Your Ref: OWPC3483
Our Ref: EG/57/14/A
Please ask for:
Simon Davis

Town & Country Planning (Control of Advertisement) (England) Regulations 2007 (as amended)

1 No internally illuminated fascia sign, 1 No externally illuminated fascia sign, 1 No externally illuminated projecting sign, 2 No non illuminated wall mounted dibond panels on front elevation.

The Barnham Hotel 28 Barnham Road Barnham

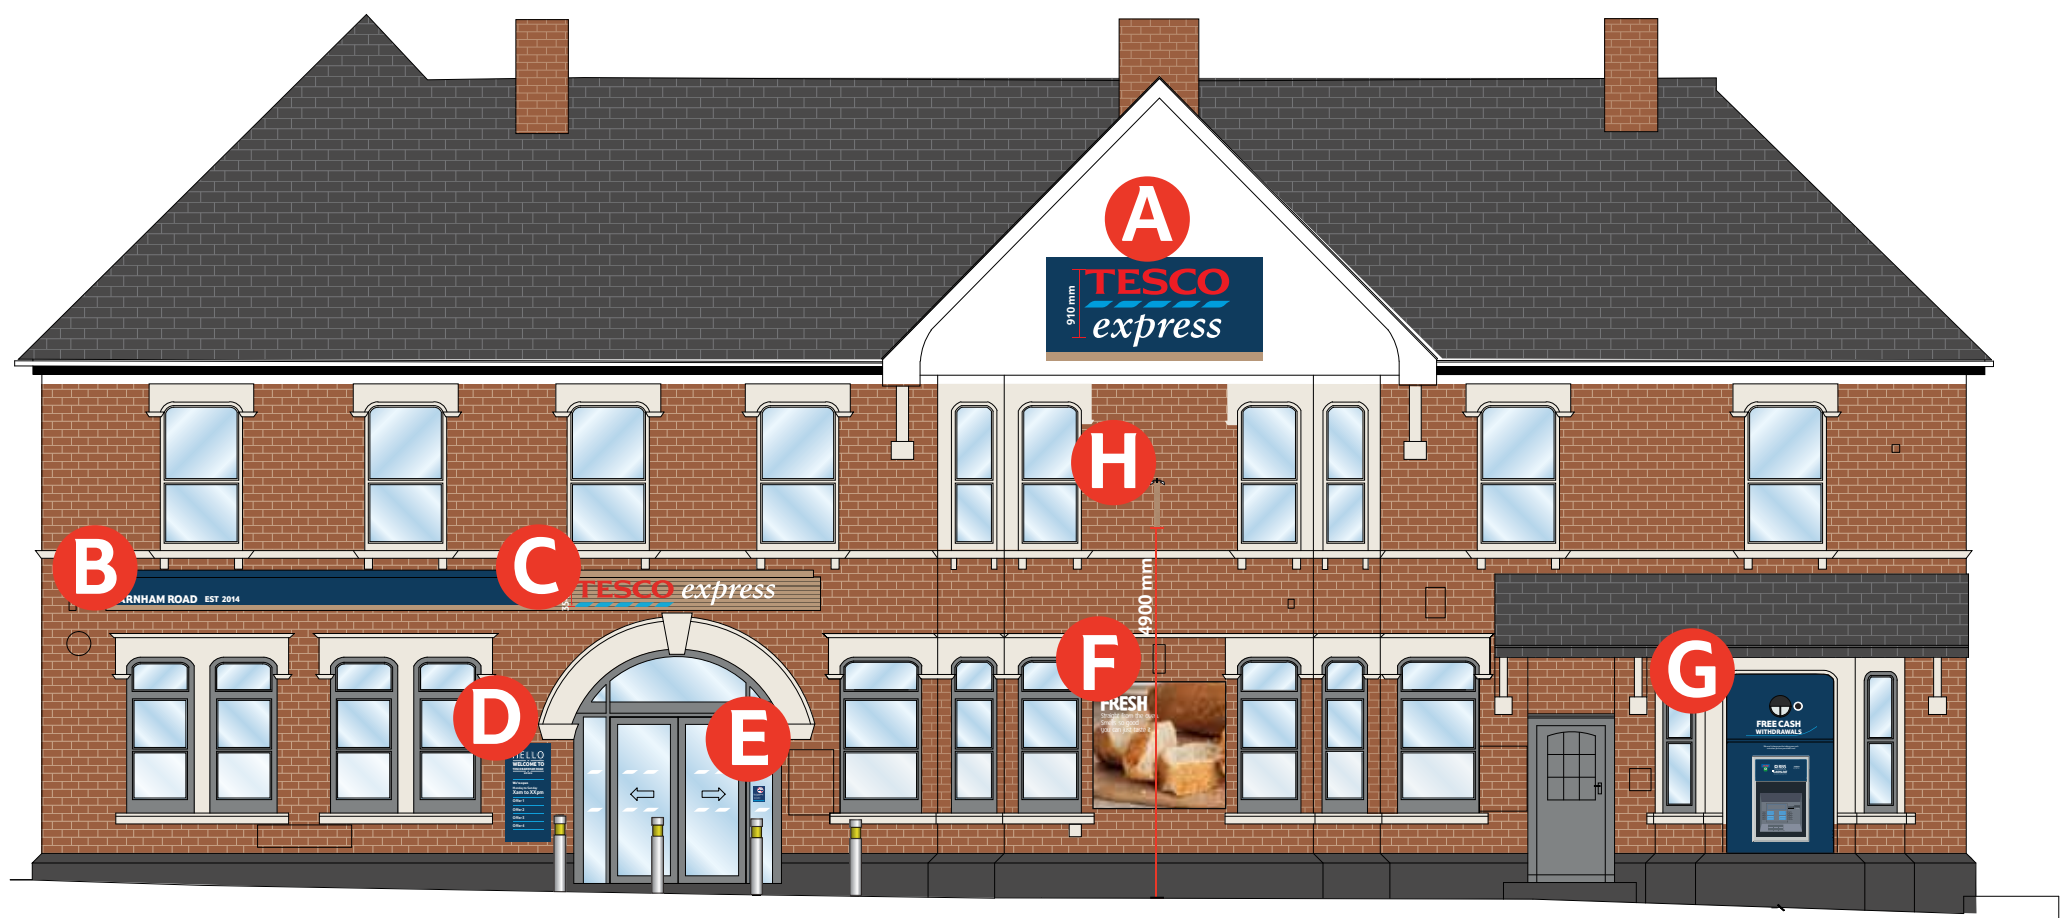
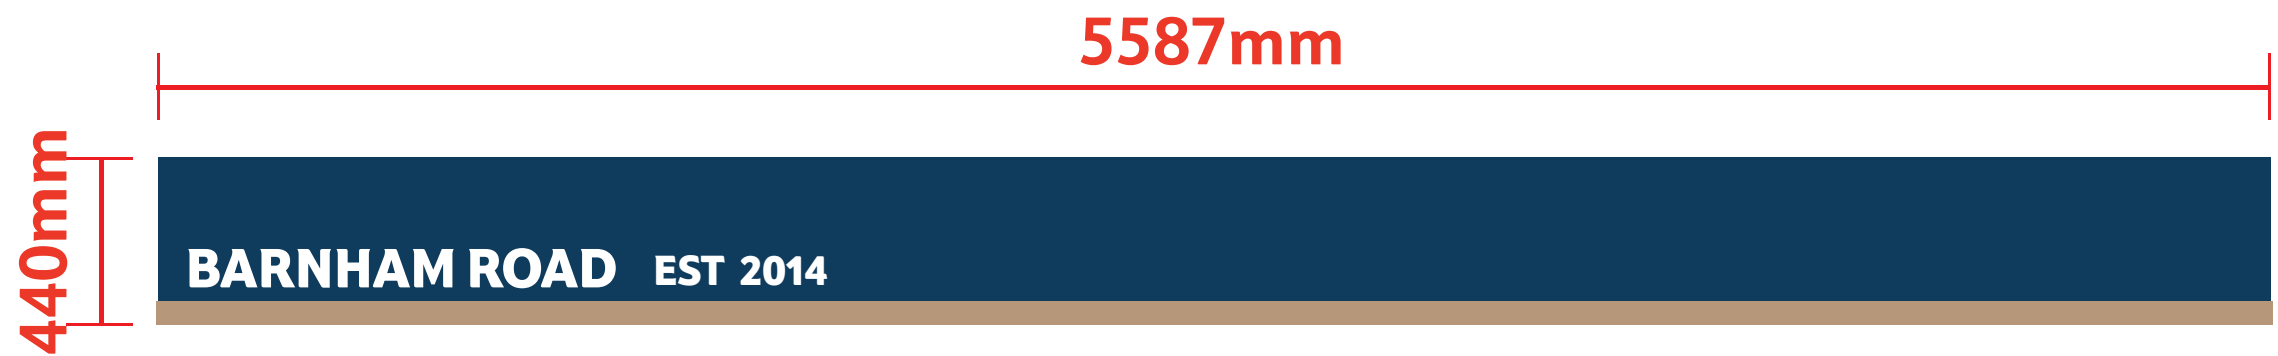
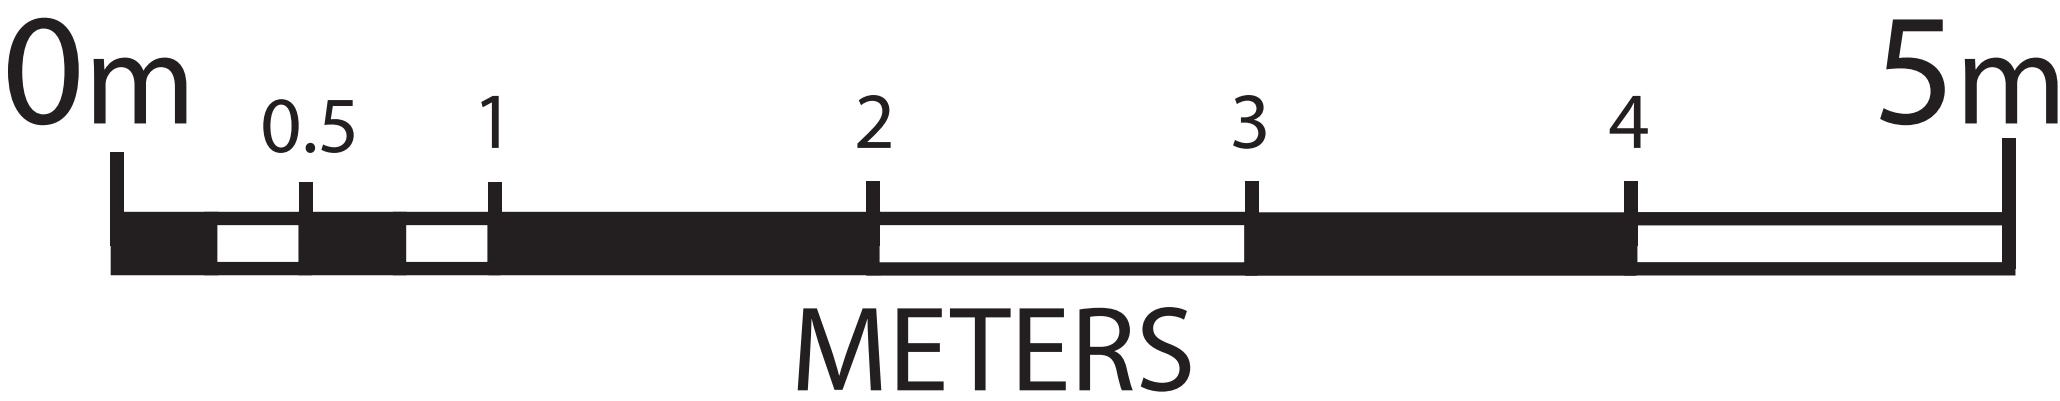
The parish council objects to sign (f) as being unnecessary street clutter and out of keeping with the appearance of this landmark building. The Barnham and Eastergate Neighbourhood Plan seeks to protect the environment and preserve the appearance of important buildings as well as to avoid unnecessary clutter by signage.
